## KITTITAS COUNTY COMMUNITY DEVELOPMENT SERVICES

January 21, 2009

### RE: Smithson Road Short Plat (SP-08-00033)

Kittitas County Community Development Services hereby grants **conditional preliminary approval** to the Smithson Road Short Plat (SP-08-00033), subject to the following conditions:

SMITHSON ROAD SHORT PLAT
 PART OF SECTION 34, T. 19 N., R. 18 E., W.M.
 KITTITAS COUNTY, WASHINGTON

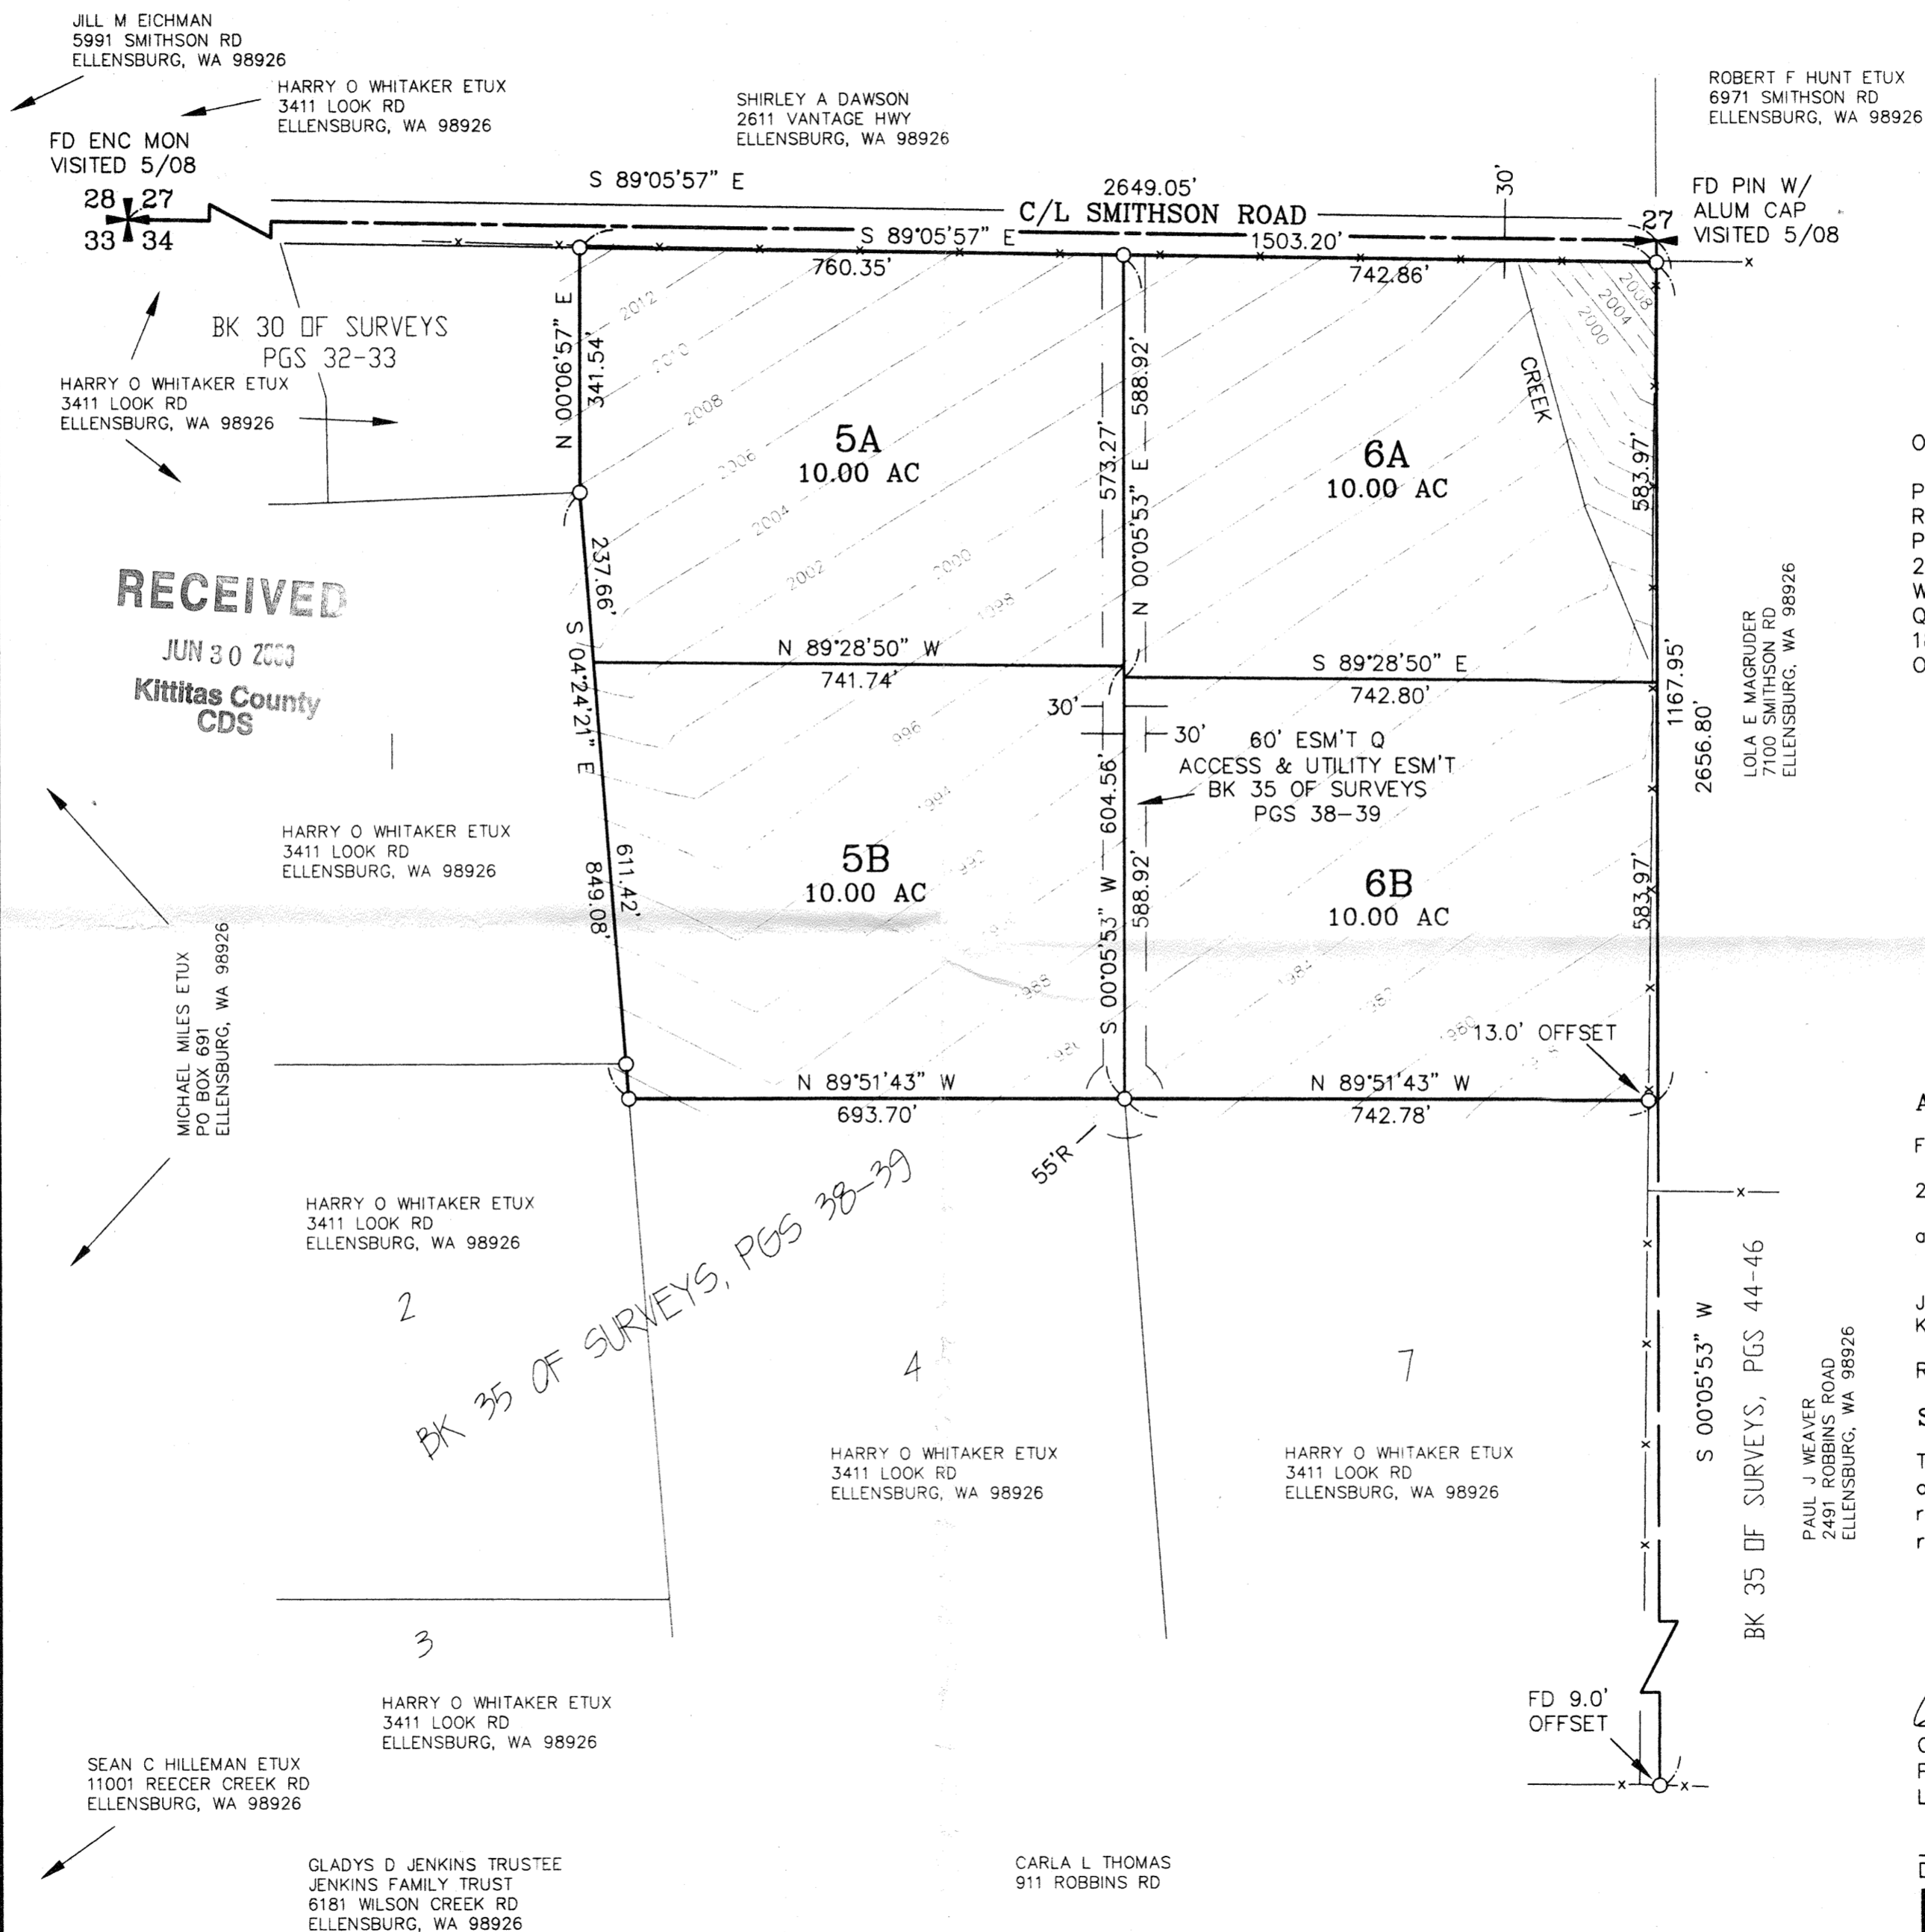
1. Both sheets of the final mylars shall reflect short plat number SP-08-00033 and an accurate legal description/map numbers shall be shown on the face of the final plat.
2. Full year's taxes must be paid on all tax parcel numbers pursuant to the requirements of the Kittitas County Treasurer.
3. One-time split provision. These properties have exhausted the use of the one-time split provision provided by KCC 17.31.040. No further division of this property will be allowed.
4. Replace plat note 8 with the following language:

5. The remaining plat notes submitted on the preliminary drawings shall also be submitted on the final mylar drawings. Additionally, the following plat notes shall be added to the final mylar drawings:

- All development must comply with the International Fire Code (IFC) and its appendices.
  - Pursuant Kittitas County Code 17.31.040, this short plat has exhausted the use of the one-time split provision allowed per Kittitas County Code. No further one-time splits are allowed for the subject parcels and subsequent parcels created via this short plat.

- All lots of the Smithson Road Short Plat SP-08-00033 shall share a single ground water withdrawal of no more than 5,000 gallons per day. No more than ½ acre of lawn and garden shall be irrigated from this ground water withdrawal.

- Metering will be required on all residential well connections and metering results shall be recorded in a manner consistent with Kittitas County and Washington State Department of Ecology requirements.

*The approval of this division of land includes no guarantee that there is a legal right to withdraw groundwater within the land division. The approval of this division of land provides no guarantee that use of water under the ground water exemption (RCW 90.44.050) for this plat or any portion thereof will not be subject to curtailment by the Department of Ecology or a court of law.*
